DECISION DELEGATED TO HEAD OF PLANNING

Application No: H06-1103-25 **Applicant:** Mr E Harris
Proposal: Change of Use of Storage Barn to Create Residential Dwelling
Location: Blazegate Lutton Spalding
Terminal Date: 6th January 2026

Project	Drawing	date	october 2025
Proposed Change of Use to Dwelling	SITE LAYOUT & LOCATION PLAN	scale(s)	1:500 & 1:1250 @ A3
Blazegate Luton		DRG. No.	HARR / pl / 01
Spalding PE12 9HU

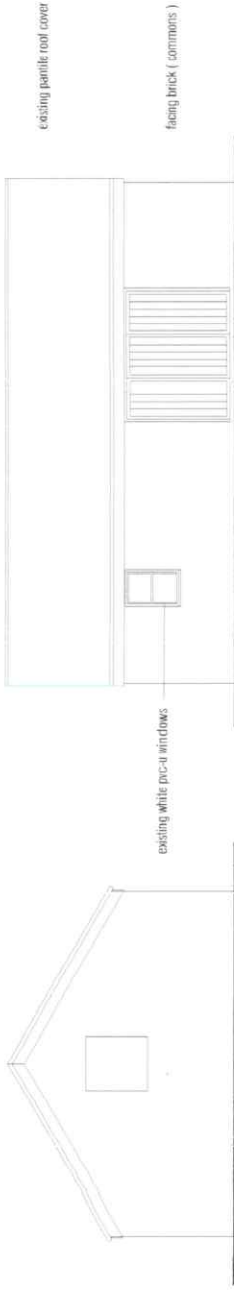
I note that the applicant intends to treat foul waste using a package treatment plant. Within Drawing No. HARR/pl/01, it is indicated that the applicant intends to discharge the treated foul water from the treatment plant to the ground via infiltration. Please note that the applicant must ensure that the system is in line with the General Binding Rules for Small Sewerage Discharges. Should the applicant's proposals change to include the discharge of treated foul water to a watercourse, consent would be required under Byelaw 3. Please note that any consent granted for the discharge of treated foul water is likely to be subject to a Treated Foul Water Development Contribution fee (TFWDC) as outlined within our Development Control Charges and Fees.

"A note should be added to the proposed site plan to say that the existing access will be upgraded to Lincolnshire County Council's Specification."

existing portile roof
velux rooflights dark grey
black horizontal cladding to external
existing screen wall

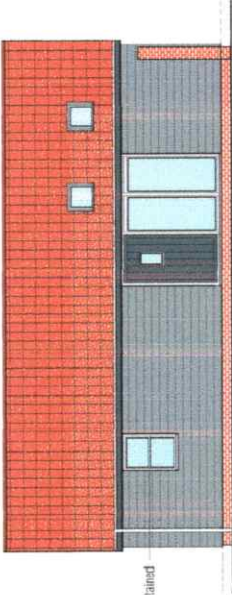
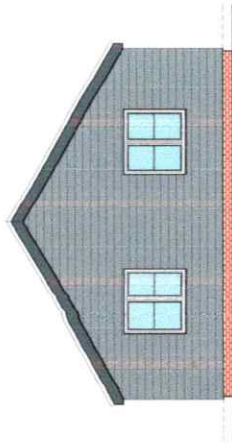
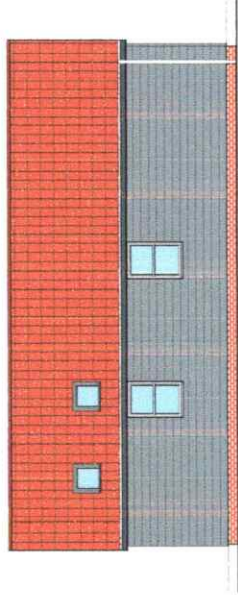
4. Whilst the other changes proposed are minor, the proposed replacement of materials represents a significant change to the appearance of the building. The resultant building, whilst a continuation in

the scale and overall mass of the existing structure, would be clearly visually distinct from its predecessor due to the change in materials. As a result of the extent of the changes, it cannot be said that the design is sympathetic to the appearance of the existing building.

The existing building is of no architectural merit. Moreover, the alteration in materials proposed would represent such a significant change to render the design unsympathetic to the host building. Therefore, the proposal is considered to fail to conform to Points 2 and 4 of the Policy 23, and accordingly the principle of development is considered unacceptable.

section

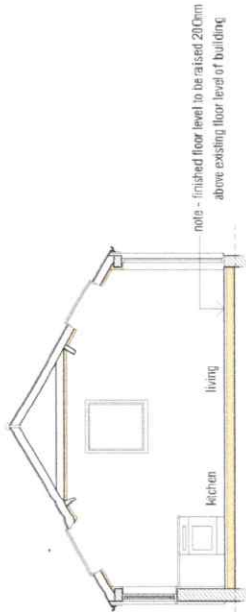
The finished floor level of the dwelling has been proposed at 0.5m above the level of the adjacent road. We advise that finished floor levels should be set in line with the South East Lincolnshire flood risk advice matrix, found in Appendix C of the Strategic Flood Risk Assessment. Finished floor levels for single storey dwellings should be informed by the 2115 0.1% breach hazard maps and be based on the levels found at the site rather than the adjacent road level.

It is proposed that finished floor levels would be raised by 0.2m, which would result in the finished floor level of the dwelling being approximately 0.5m above Blazegate Road level due to changes in topography. The flood depths shown within Appendix B are relative to ground level as opposed to road level. Whilst the data underpinning the SFRA is broad, depths shown in Appendix B should be taken from the spot the location of development, not nearby road levels. Therefore, the increase in height relative to the road, whilst better than no alteration, would not be equivalent to an overall raise of 0.5m. For the purposes of the SFRA and Policy 4, without a comprehensive topographic survey to show otherwise, the increase in finished floor level is taken to be 0.2m.

The standing advice given by the Environment Agency is that finished floor levels should be raised above the maximum expected flood depths, shown here to be up to 1m. The submitted flood risk assessment has not demonstrated changes in the topography which would result in depths not reaching their maximum; and therefore, it must be assumed that this maximum depth is applicable here. As such, even if it was conceded that the raise in finished floor level is tantamount to a 0.5m raise, the finished level would still be 0.5m below flood depths. This is consistent with the approach taken in the Environment Agency's objection.
